# KITITAS COUNTY

## DEPARTMENT OF PUBLIC WORKS

### MEMORANDUM

**TO:** All Staff  
**FROM:** Public Works Plan Review Team  
**DATE:** August 4, 2025  
**SUBJECT:** VA-25-00004 Jones

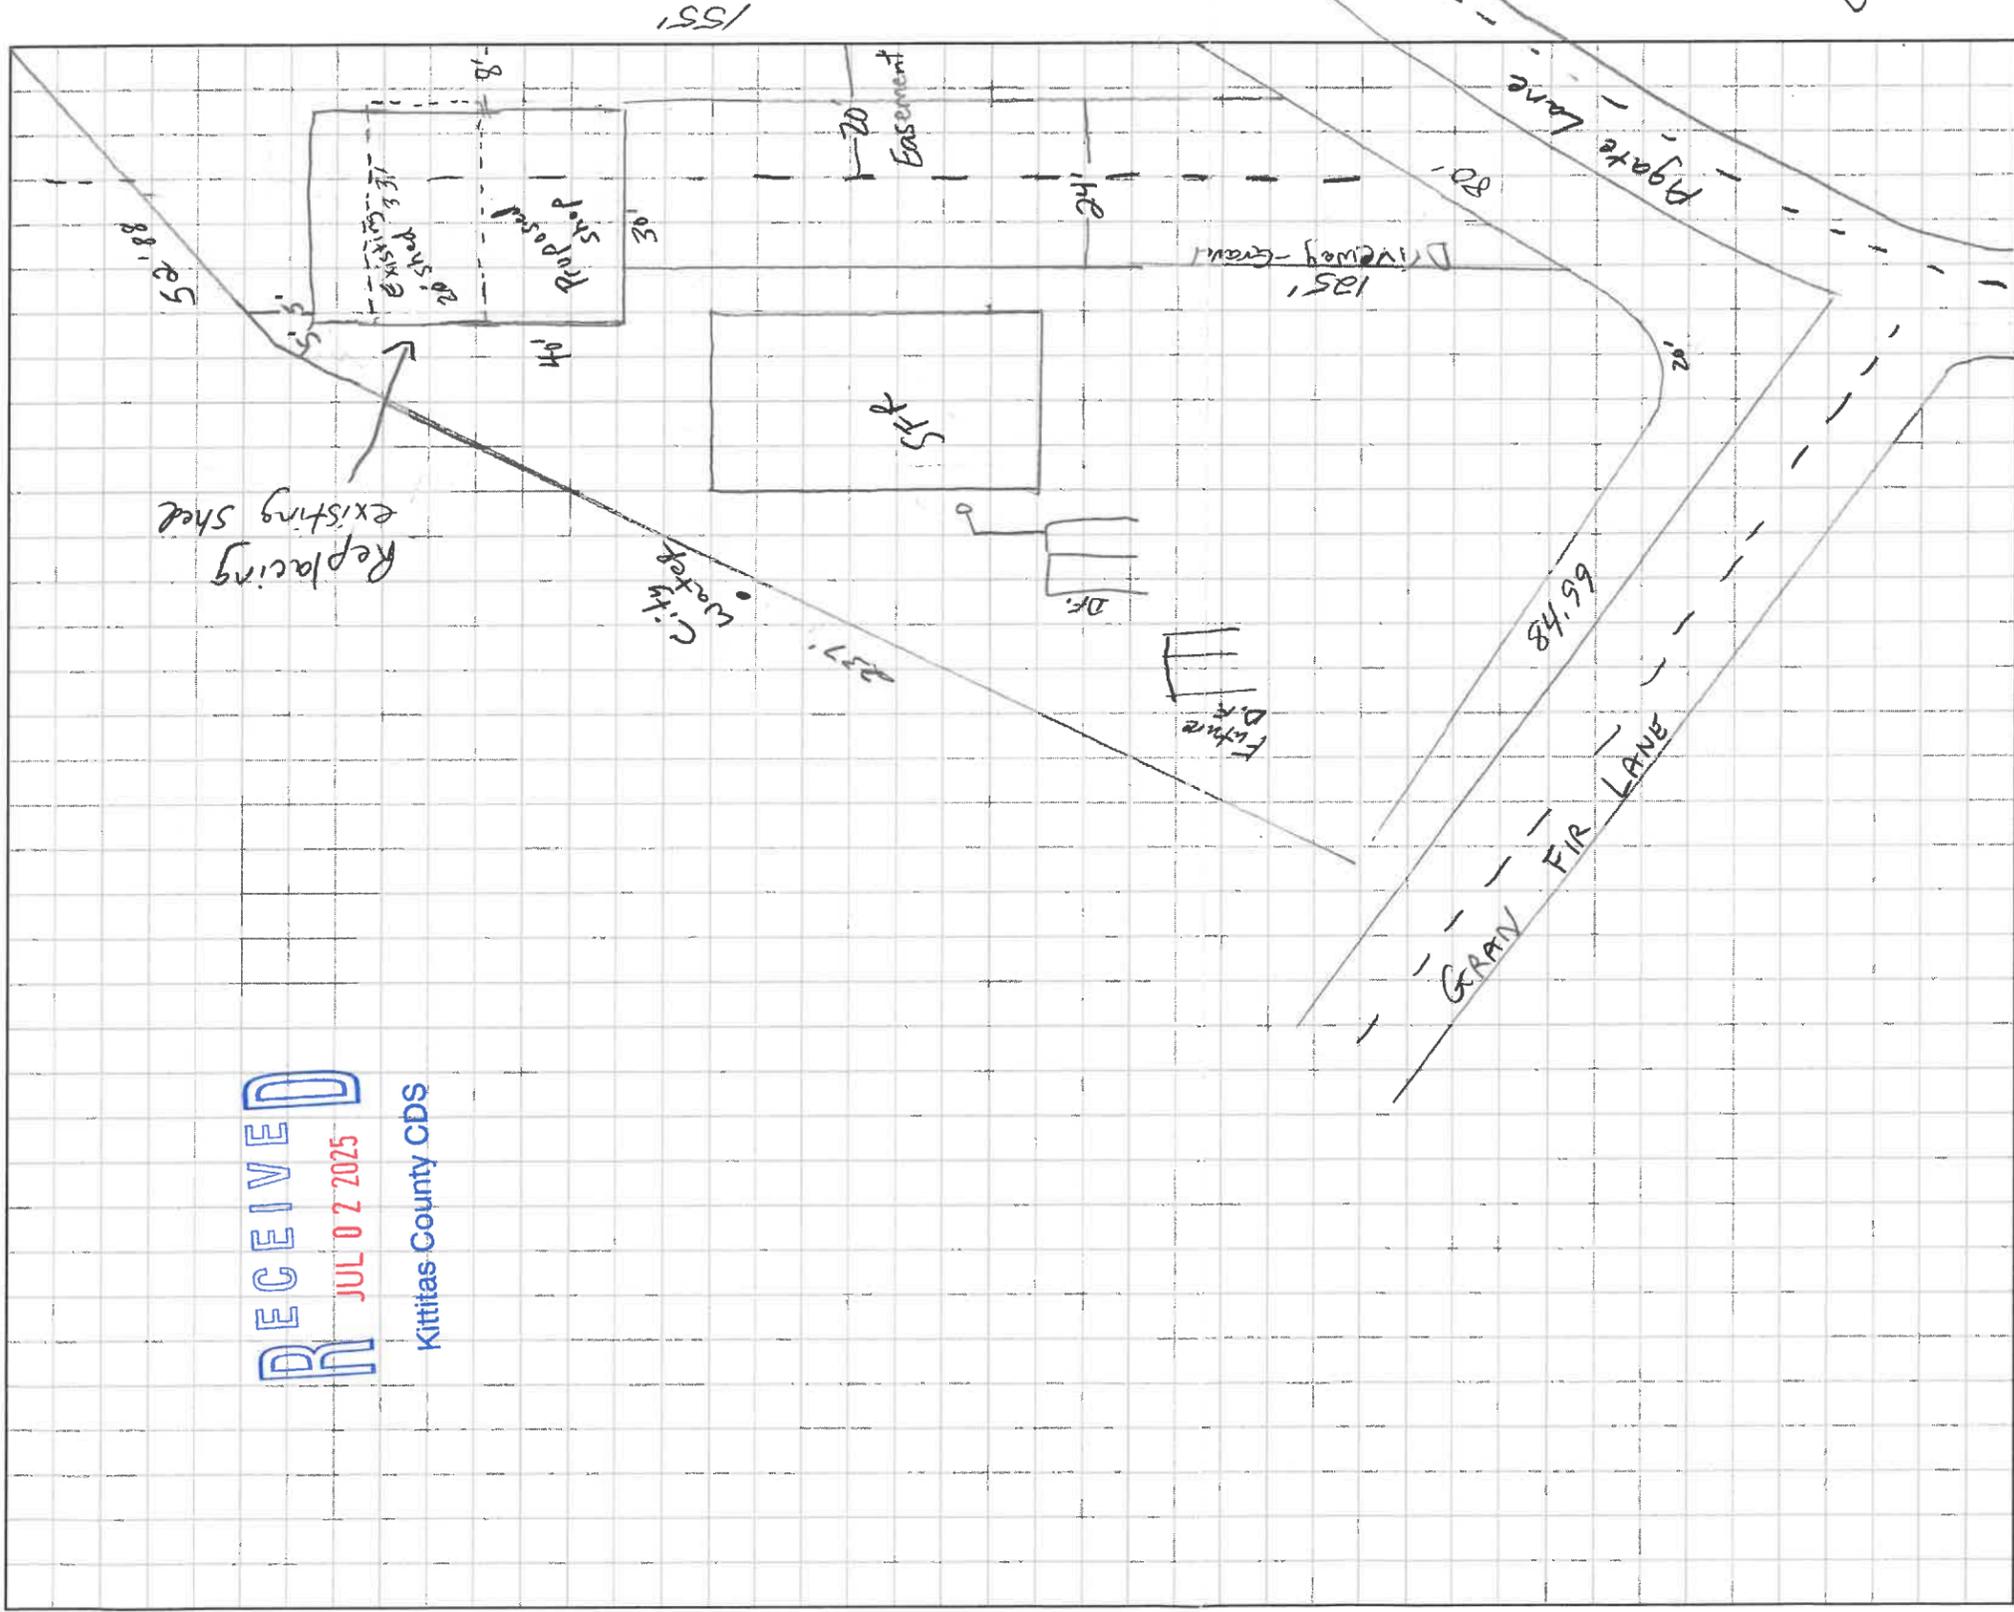
<b>SURVEY</b>	1. The proposed shop expansion falls on an existing 20' wide easement (per Survey 201806200044). The easement shall need to be vacated prior to approval, unless the purpose of the easement specifically would not be impacted by a building OR unless specifically approved by the Building Official. (JT)
<b>TRANSPORTATION CONCURRENCY</b>	No Comments.
<b>FLOOD</b>	No comments. (SC)
<b>WATER MITIGATION/ METERING</b>	No comments. (SC)
<b>AIRPORT</b>	No Comments.
